21 January 2014

Our Ref : **F/19/13/**
Your Ref:

Proposed development and operation of a waste treatment facility. This is a County Matter and will be determined by West Sussex County Council.
New Circular Technology Park, Former Ford Blockworks, Ford Airfield Industrial Estate, Ford

Title
ELEVATIONS

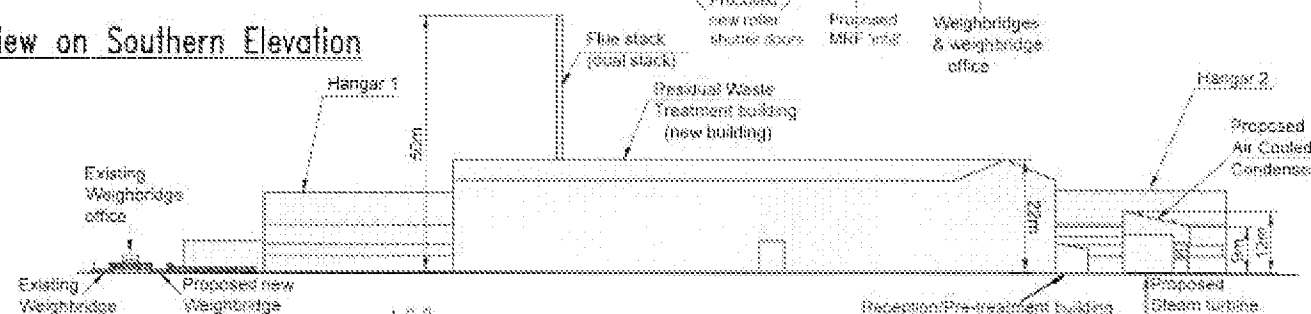
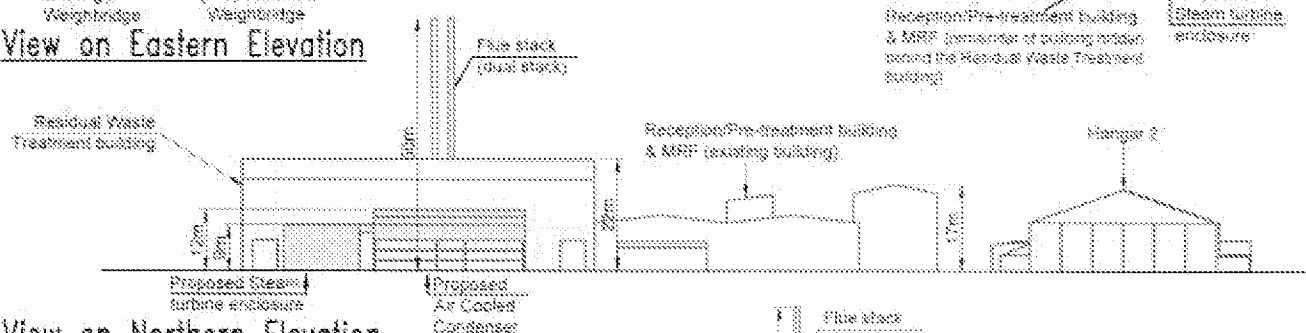
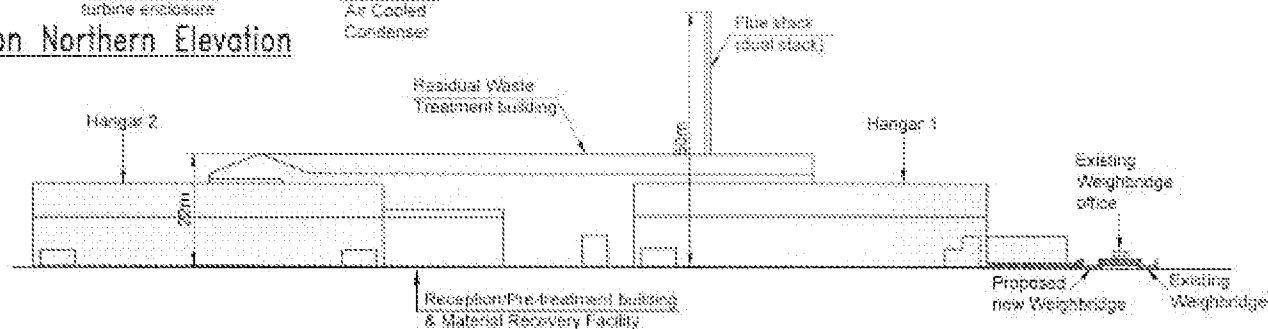
heights between 30 metres and 70 metres, a stack height of 50 metres has been chosen as at this point the impact when operating at its daily limit the impact is small. Due to the significant visual impact the dual stack system poses, officers recommend that further work should be done to justify the height of the stack. It is thought that it could potentially be reduced to 45 metres as at this point the significance of emissions becomes negligible. Comments are sought from colleagues at the Sussex Air Quality Partnership on this point as a reduction, albeit by 5 metres would lessen the visual impact of the structure.
